Item No. **Report of the Head of Planning, Sport and Green Spaces**

Address 11 WALNUT WAY RUISLIP

Development: Single storey side/rear/front extension and single storey front extension involving conversion of garage to habitable use and raising of roof and installation of 2 x side dormers to allow for additional habitable use

LBH Ref Nos: **10279/APP/2014/723**

drawing title
Existing & Proposed Side Elevation

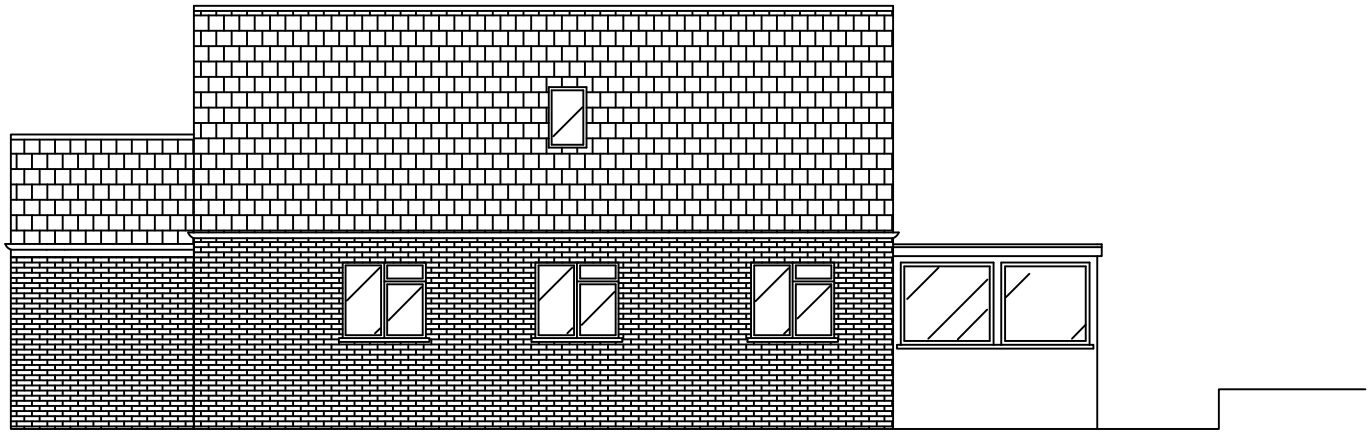
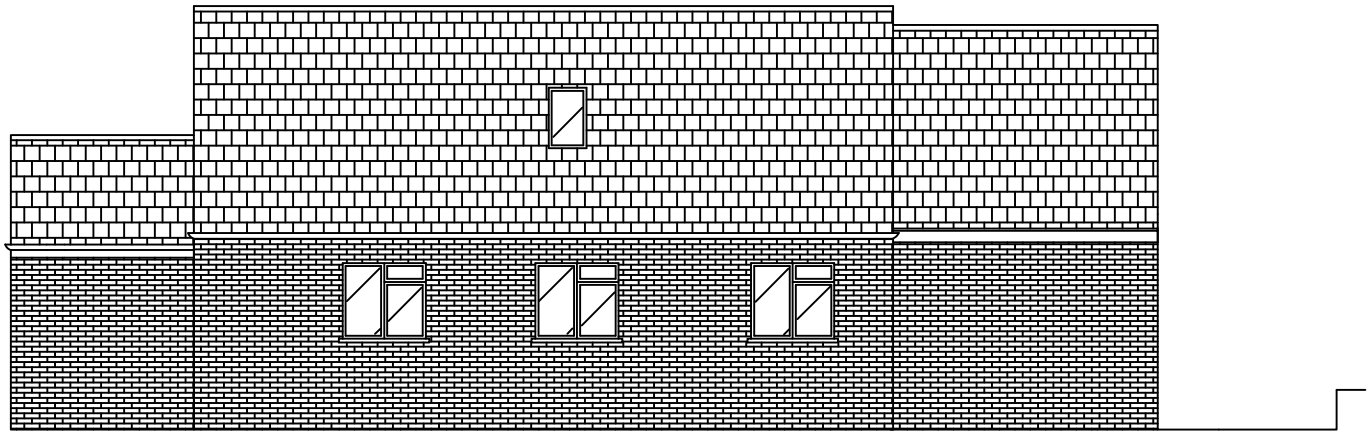
Turning to the proposed side dormers and roof enlargement. The Council's design guidance requires dwellings to maintain a 1m distance separation to side boundary lines for all first floor extensions. This distance separation is required to be increased to 1.5m when the ground floor is built up to the side boundary line. The proposed roof extension and dormers would create the effect of a second storey, which would be only 0.8 metres from the boundary line. Therefore, the development would result in an unacceptable closing of the open space to the side of the dwelling, having an unacceptable impact on the streetscene.

In terms of the appearance of the dormer, it is important that the proportions remains secondary to the size and scale of the roof form and does not unsettle its design unsympathetically. HDAS-EXT guidance paragraph 7.8 states that the dormer should be set above the eaves by 0.5m. The proposed dormers would not comply with set in guidelines from the eaves of the main roof, as there would only be a 0.2m set in. Furthermore, the dormer windows have a significant visual prominence on the streetscene which would create an unfavourable design in the roof form. As such, the design and proportion are both obtrusive and unsympathetic to the original dwellinghouse and the streetscene contrary to part 2 policies BE13, BE15 and BE19 of the Hillingdon Local Plan: UDP Saved Policies (2012) in this regard.

The proposed development would alter the dormer windows in the side elevation of the property, however, the outlook would largely remain the same and would cause no significant harm to the neighbouring occupiers in terms of overlooking.

The proposed side dormer window and roof extensions, by reason of their position, size, scale, bulk design and proximity to the side boundary line would result in discordant and intrusive features that would be harmful to the character and appearance of the original property, the visual amenity of the streetscene and the character and appearance of the wider area. Therefore, the proposal would be contrary to Policy BE1 of the Hillingdon Local Plan: Part One - Strategic Policies (November 2012), Policies BE13, BE15 and BE19 of the Hillingdon Local Plan: Part Two - Unitary Development Plan Saved Policies (November 2012) and the adopted Supplementary Planning Document HDAS: Residential Extensions.

drawing title
Proposed Floor Plans

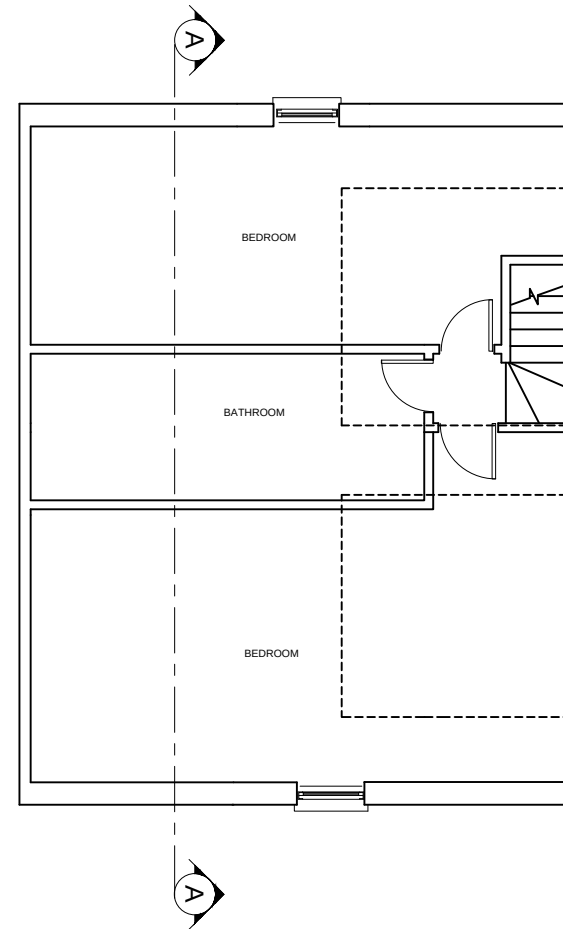
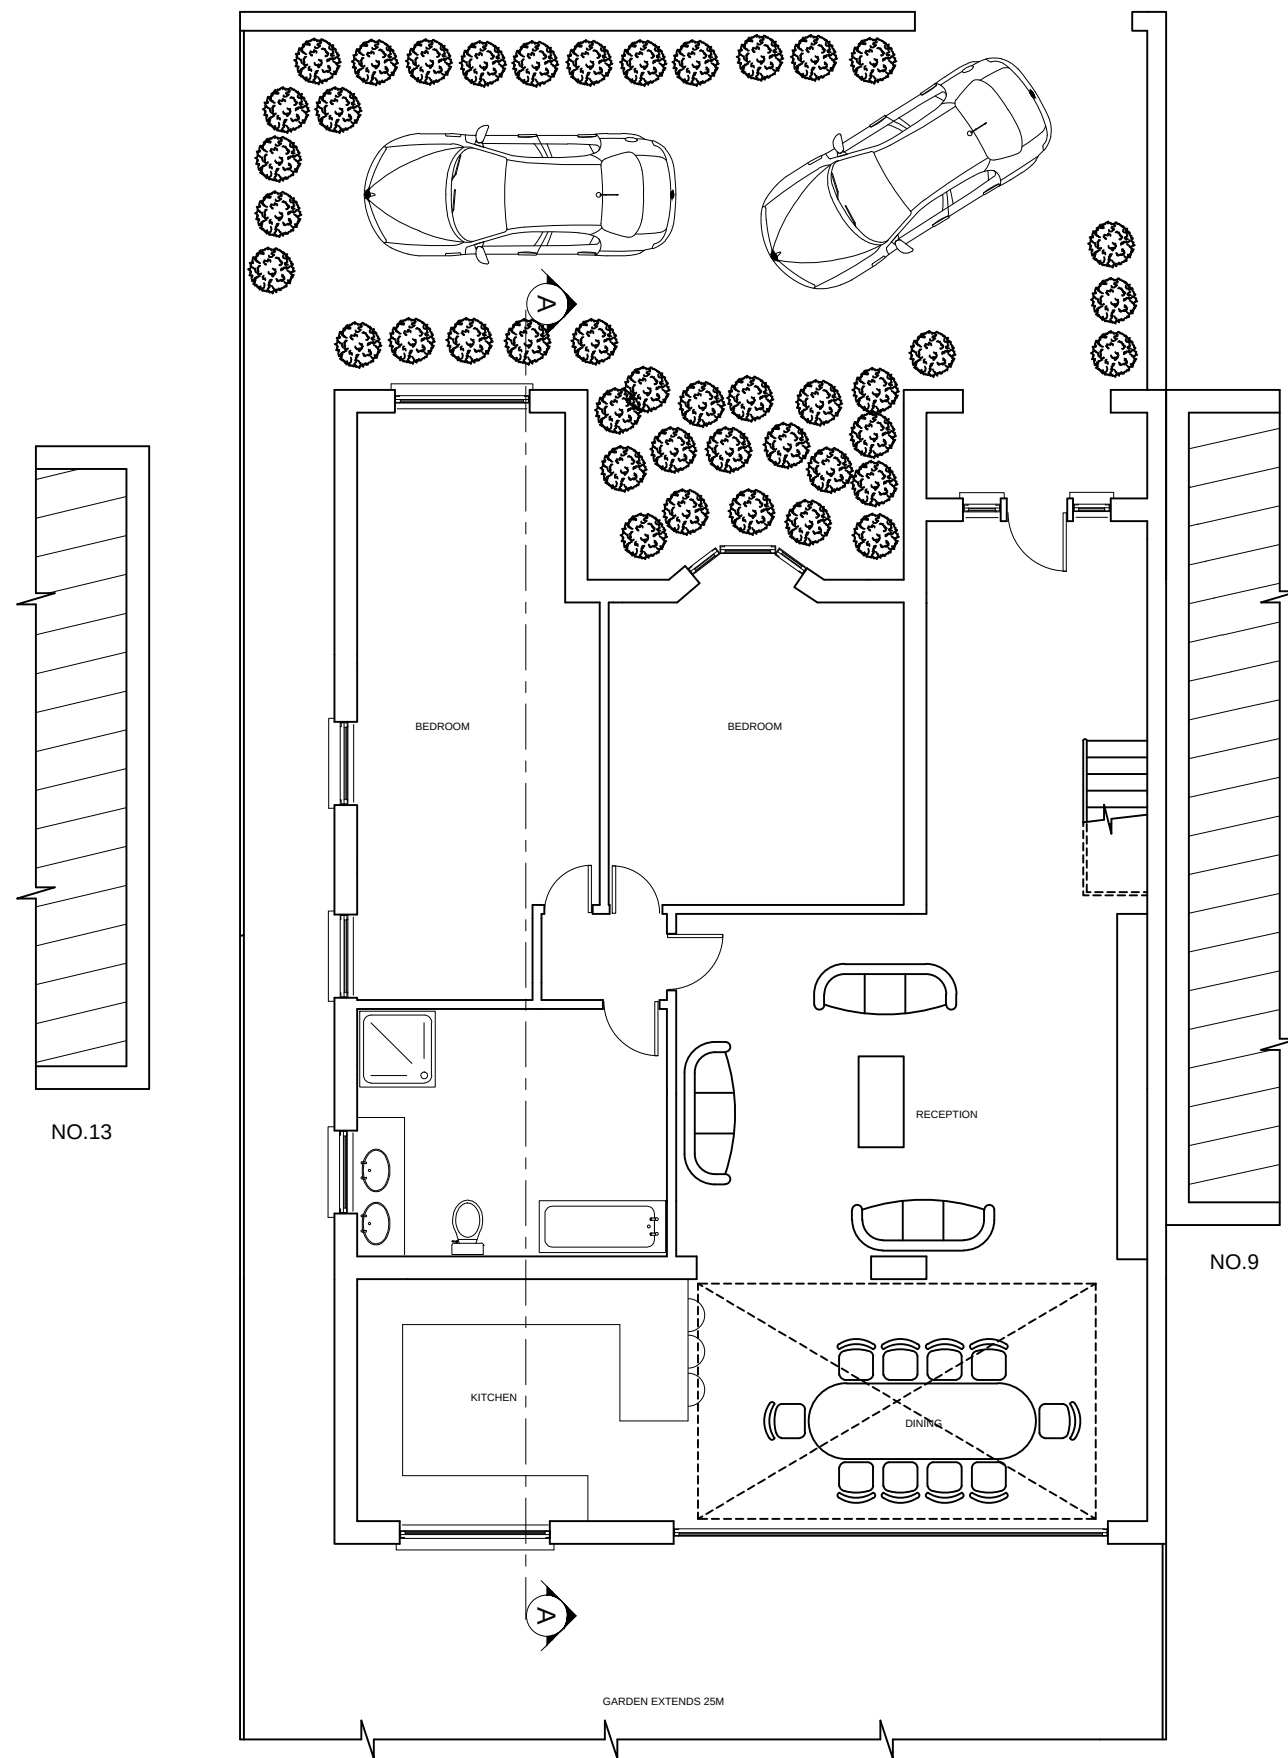
In terms of the impact on the neighbouring dwellings. The single storey rear extension would have a depth of 3.6 metres but would extend 4.14 metres past the rear elevation of No.9. At this depth along the shared boundary line, the proposed development is considered to cause unacceptable harm to the occupiers of this neighbouring property in terms of loss of light, loss of outlook and sense of dominance. Therefore, the proposal is contrary to Policies BE19, BE20 & BE21 of the Hillingdon Local Plan (November 2012).

The proposed development would result in the loss of the garage and potentially the existing parking space within the site. The applicant has provided a block plan to show two parking spaces being retained. However, the depth of the front garden area does not appear to be accurate, as it does not accord with the depths shown on the original block plan, location plan or Council's GIS system. Therefore, the proposed development is likely to result in the loss of both existing off-street parking spaces, contrary to Policy AM14 of the Hillingdon Local Plan (November 2012).

The proposed single storey rear extension, by virtue of its size, scale, bulk, depth, height and proximity to the shared boundary line would be detrimental to the amenities of the adjoining occupiers at 9 Walnut Way, by reason of overdominance, overshadowing, visual intrusion, loss of light and loss of outlook. Therefore the proposal would be contrary to policies BE19, BE20 and BE21 of the Hillingdon Local Plan: Part Two - Unitary Development Plan Saved Policies (November 2012) and the adopted Supplementary Planning Document HDAS: Residential Extensions.
